## DECISION DELEGATED TO HEAD OF PLANNING

**Application No:** H16-0656-25      **Applicant:** A Quantrill

**Proposal:** Erection of two-storey detached dwelling - Approved under H16-0748-21. Amendments to use TBS Audley Antique brick (Red), white cement instead of ordinary cement & light green UPVC windows & doors

**Location:** 117a Albion Street Spalding Lincolnshire

Elevation 01 - Front

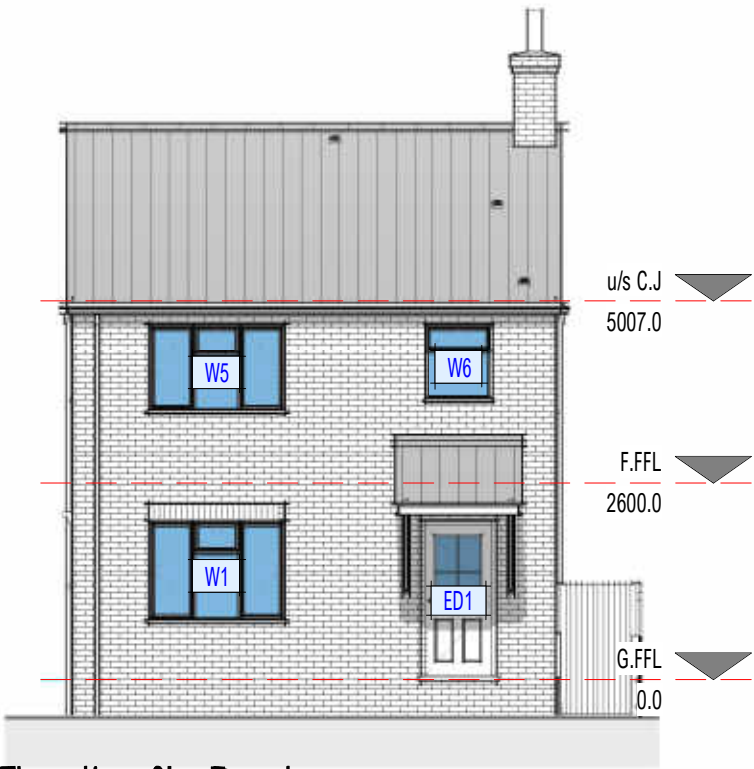
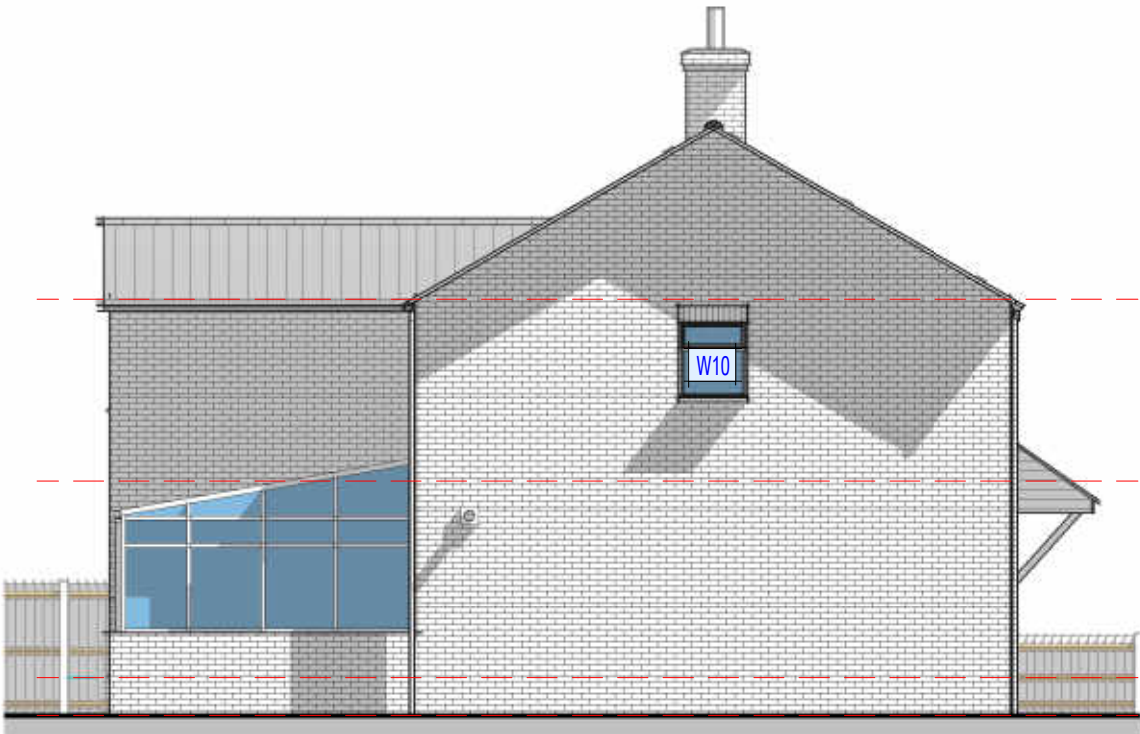
8. The amendments must not result in a fundamental change in the design of the building. Both bricks selected are red, and are not immediately visibly distinct. The change from white UPVC to green would have no significant overall impact. Likewise, the change in cement colour would have no discernible impact.
